COMPLETED 04/21/08 SH DRB CASE ACTION LOG (SITE DEVELOPMENT PLAN)

DRB Application No.: 07DRB-70305

Project # 1005132

Project Name: NORTH ALBUQUERQUE ACRES UNIT B

A1 SITE DEVELOPMENT PLAN FOR SUBDIVISION

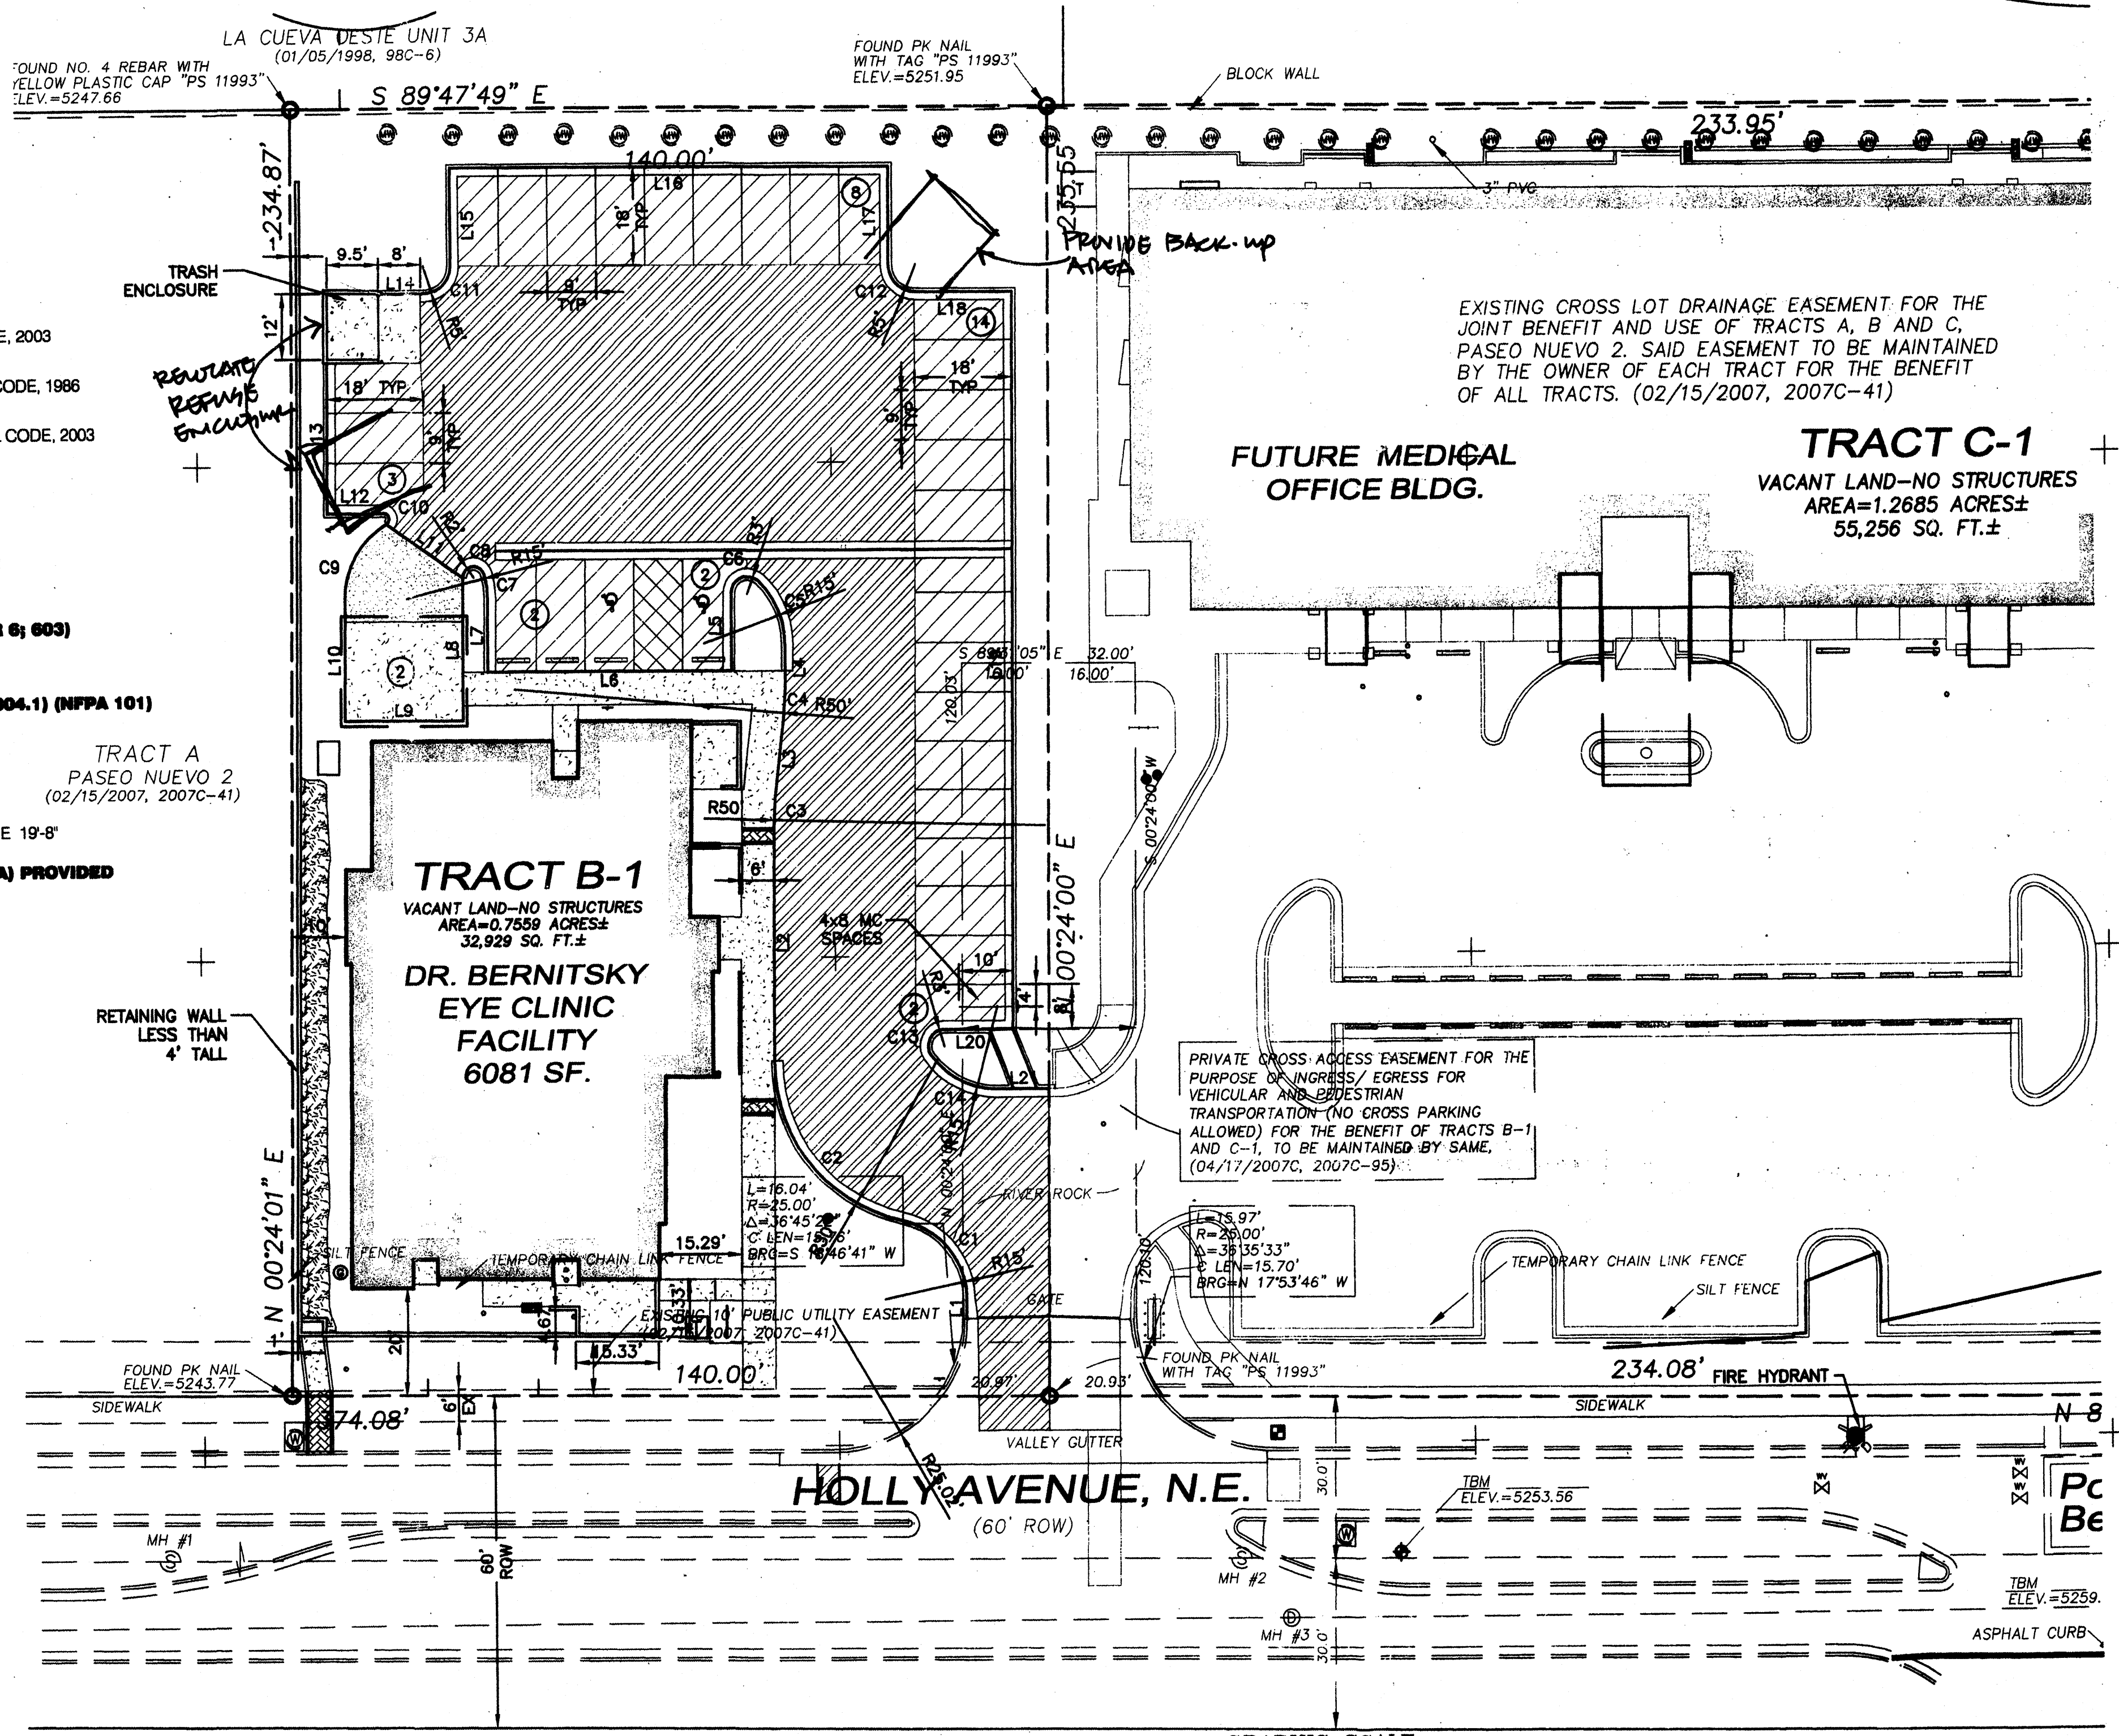
PLANNING (Last to sign): Perimeter Wall detail on Site Plan.
3 Copies
